From: Clare Dales
Sent: 28 February 2018 14:24
To: Richard Temple
Subject: RE: Planning Consultation on: FP/7/18/L

APPLICATION FP/7/18/L

Site Address: Richmond House 47A Felpham Way Felpham PO22 8PT

Description of Works: Listed Building Consent for proposed side extension to non original part of dwelling

Item/rev	Quantity	Title/Name, designation, material, dimension etc	Article No./reference
Designed by	Checked by	Approved by - date	Date
JD		January 2018	1:50
4.7a Felpham Way		Proposed Extension	
		01	Edition Sheet

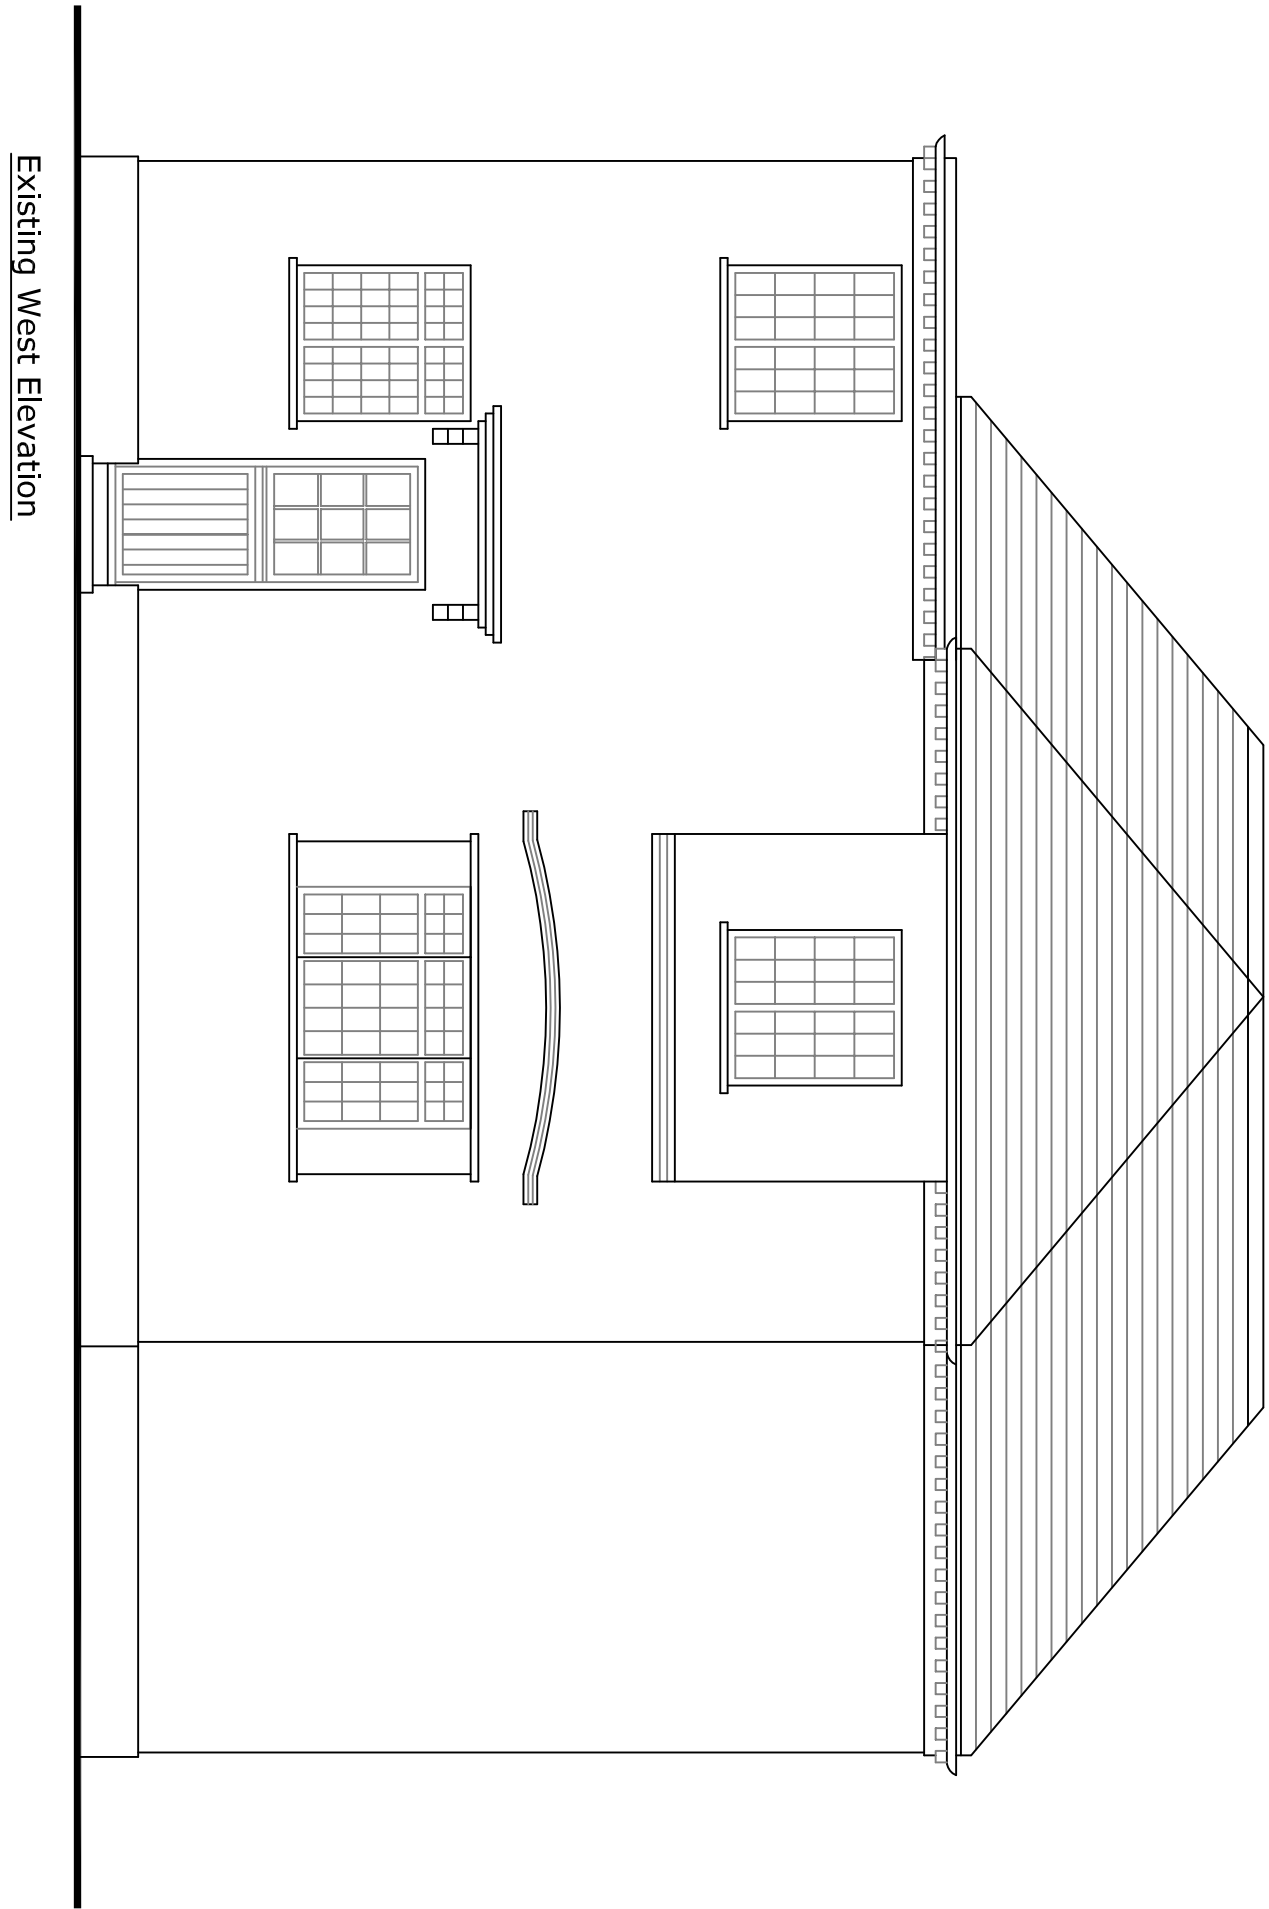
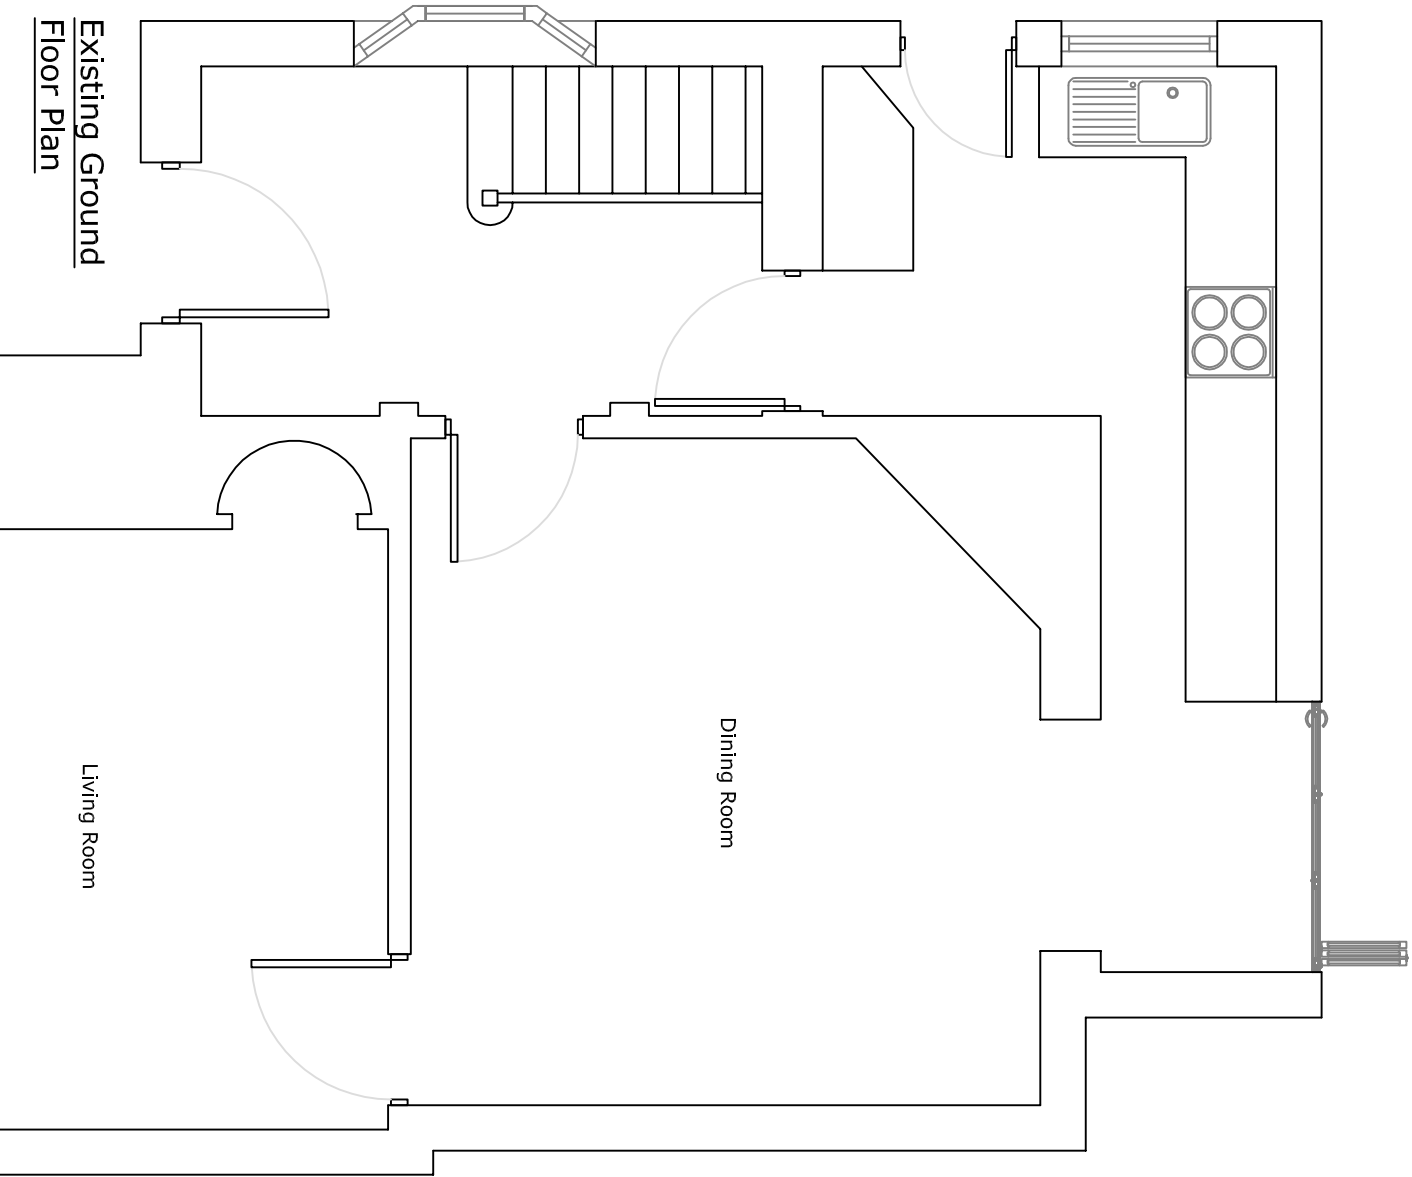
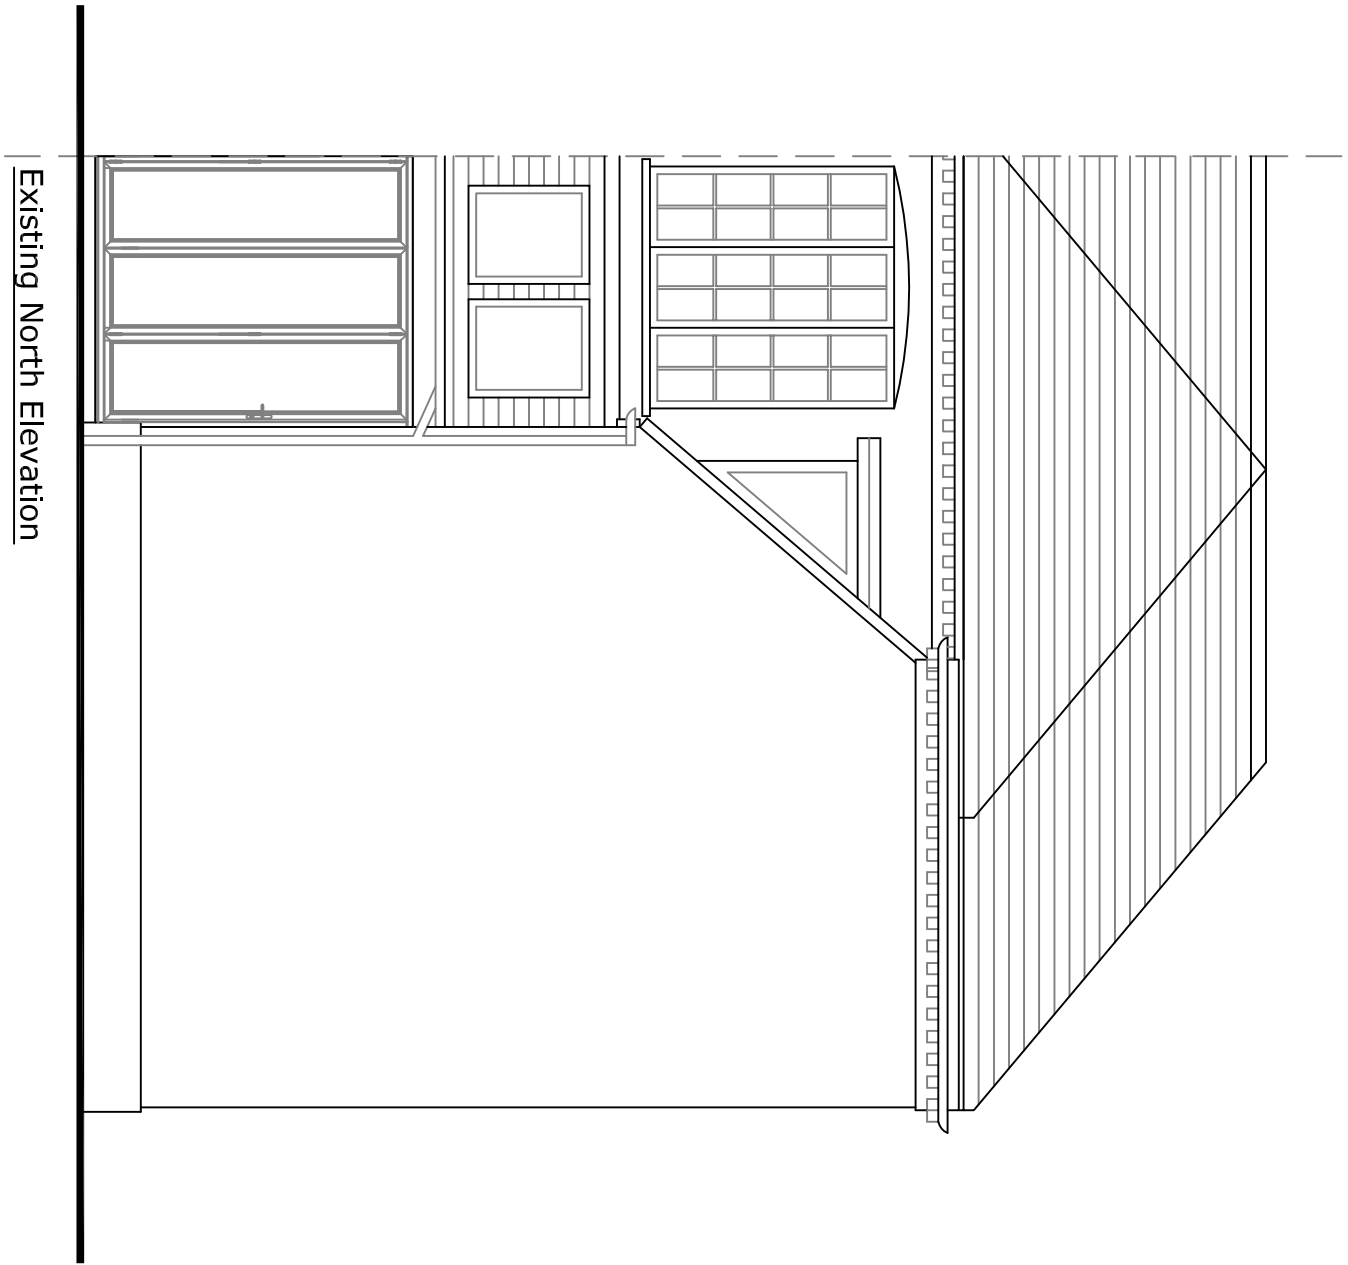
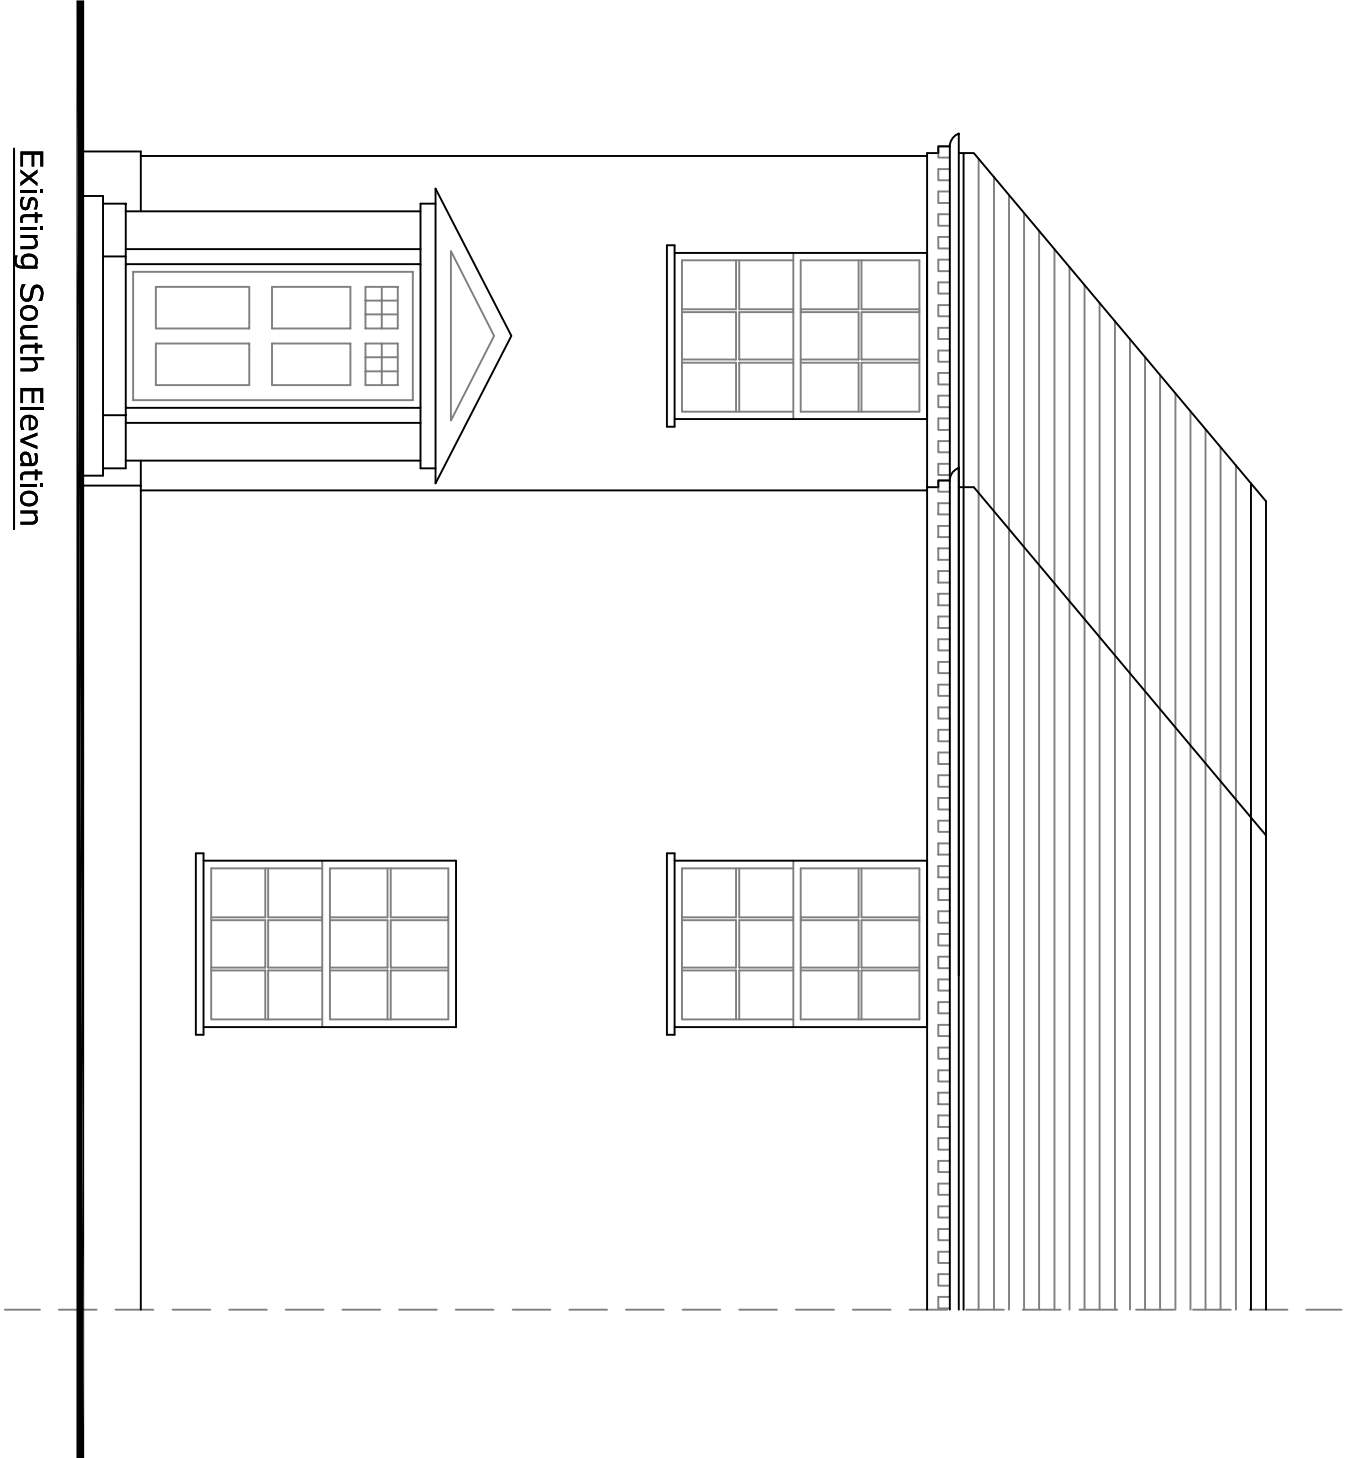
The submitted plans detail an extension, plus a solid wall with door and canopy over. The proposed extension to kitchen is supported in terms of scale, mass, location and detailing, with the exception of the bifold doors as shown on plan. Such glazing is considered out of keeping with the property. It is recommended that a single solid/cottage door be inserted within a solid wall. Fenestration may be introduced.

The solid, freestanding wall with door and canopy is recommended for refusal as this element is dominating, detracts from the main house, its existing (and proposed extension, if approved).

It is noted that the existing and proposed pedestrian and vehicular gates are shown identically. The existing gate as seen during a site visit does not match that drawn, nor would approval be recommended, due to the solid nature of the proposed, and their overly contemporary styling.
